SEA LINK – EN020026

SUMBISIÓN FOR DEADLINE 3, 9th January 2026

Nicholas Bridges RIBA FRSA

CULTURAL HERITAGE – LANDCAPE & VISUAL – CUMULATIVE DEVELOPMENT

Viewpoint 6 (a): Public Footpath (Friston 260, route 17), east of Sternfield, looking southeast

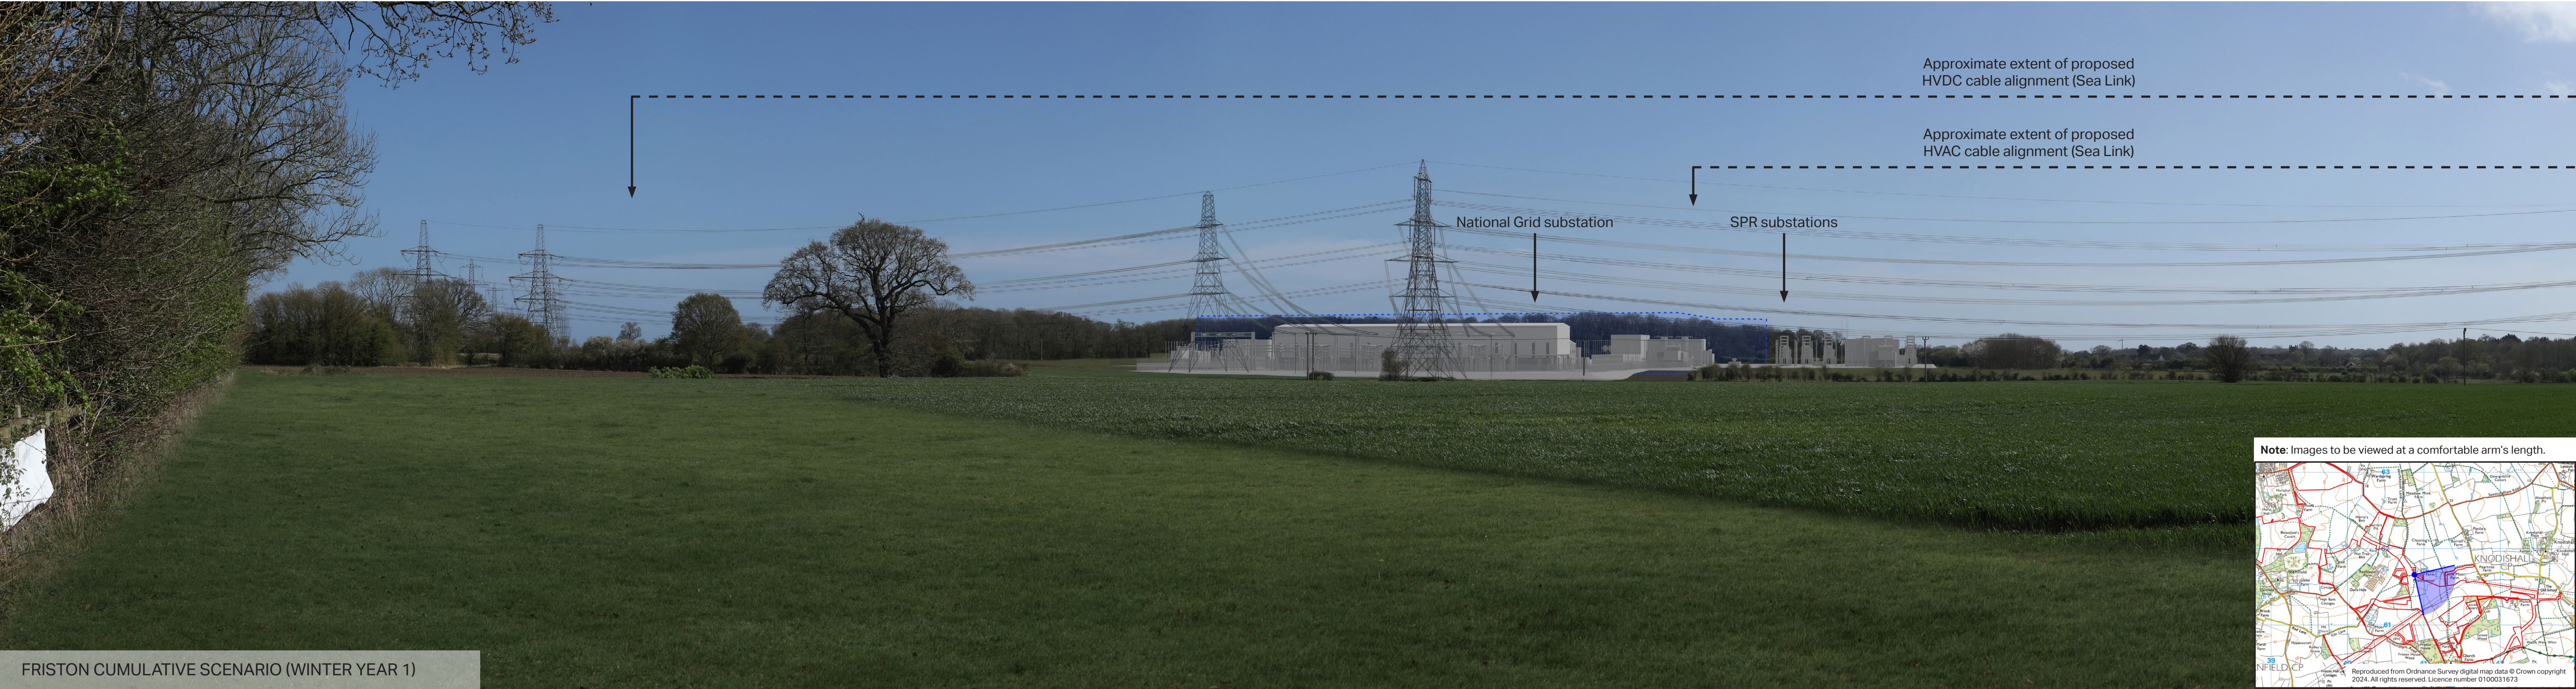
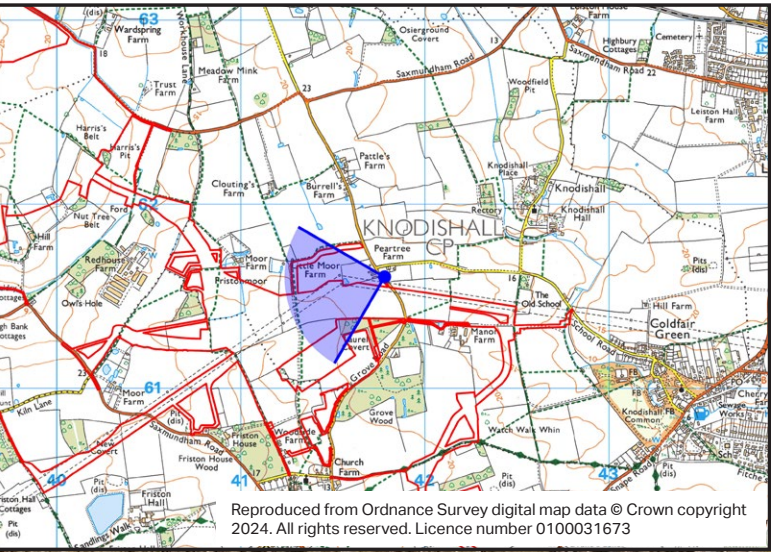
ExQ1	Question to:	Question:
1LVIA2 continued	N Bridges response continued	<p>12. It is inexplicable why the images in EN020026-000714-9.6.1 Appendix A Indicative cumulative visualisations of the National Grid and Scottish Power Renewables substations near Friston have modelled the plant with wirescape outside the converter sheds but this has not been done in the LVIA's images. The extensive wirescape around the plant on the ground, as illustrated typically in its Viewpoint 6(a), is bound to have harmful effects on landscape and visual receptors.</p> <p>13. The Applicant states in para. 5.4.30 that the design parameters are explained in Application Document EN020026-000230-6.2.1.4 Part 1 Introduction Chapter 4 Description of the Proposed Project. The Descriptions in section 4.2 Suffolk begin with descriptions of the infrastructure's components with dimensional and technical information. Saxmundham's converter station is from paras. 4.2.31 to 4.2.35. It shows the indicative view in Plate 4.1 below, which is based on the application plan below that.</p>  <p>EN020026-000230-6.2.1.4 Part 1 Introduction Chapter 4 Description of the Proposed Project Plate 4.1 – Indicative view of the proposed Saxmundham Converter Station based on the plan below</p>
